CITY OF ALBUQUERQUE

December 27, 2017

RE: **Memorial Park Anderson Heights Unit 4**
Engineer's Stamp Date: 12/18/2017
Hydrology File: N08D006F1

Based on the information provided in the submittal received on 12/19/2017 the above-referenced Grading and Drainage Plan cannot be approved for Grading Permit or for Building Permit until the following comments are addressed.

MEMORIAL PARK OVERALL GRADING & DRAINAGE PLAN

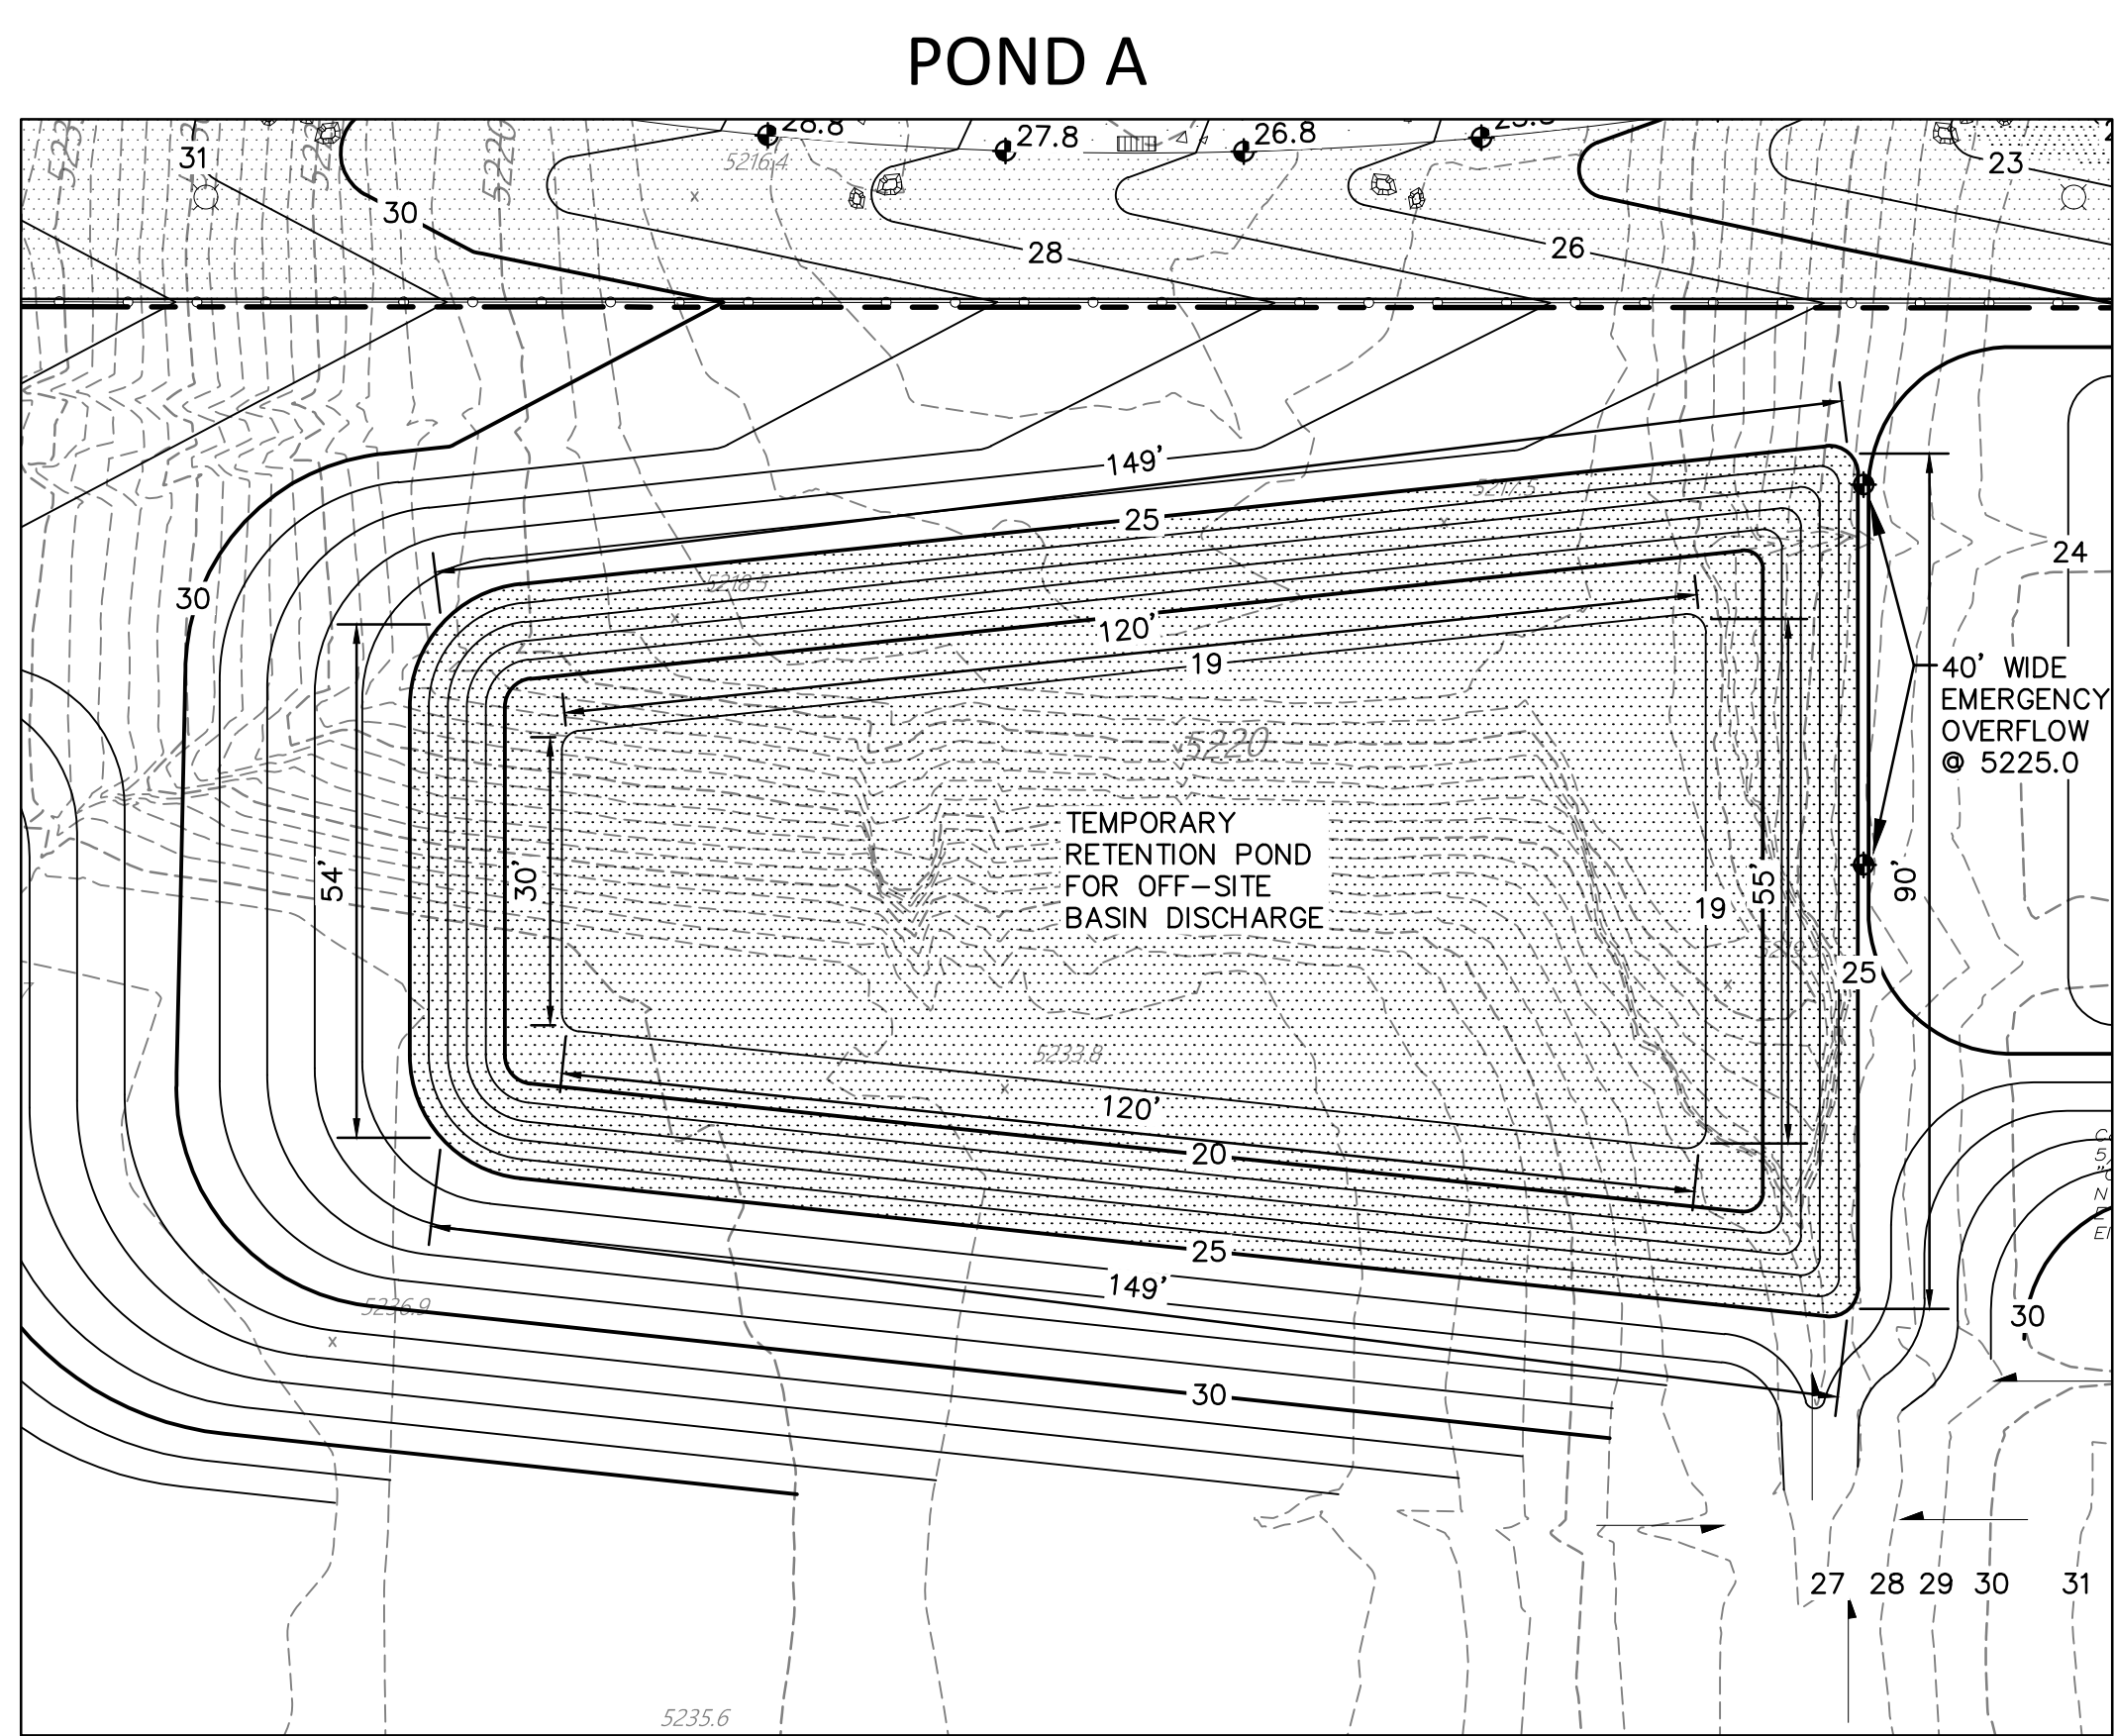
1. A Public Drainage Easement must be recorded to contain the east temporary retention pond.
2. A new Drainage Covenant must be recorded for the new pond location. The previous covenant can be released if the new covenant includes all of the ponds shown on the previous covenant.
3. Provide a letter of permission from the owner of the neighboring property for the grading on their property.
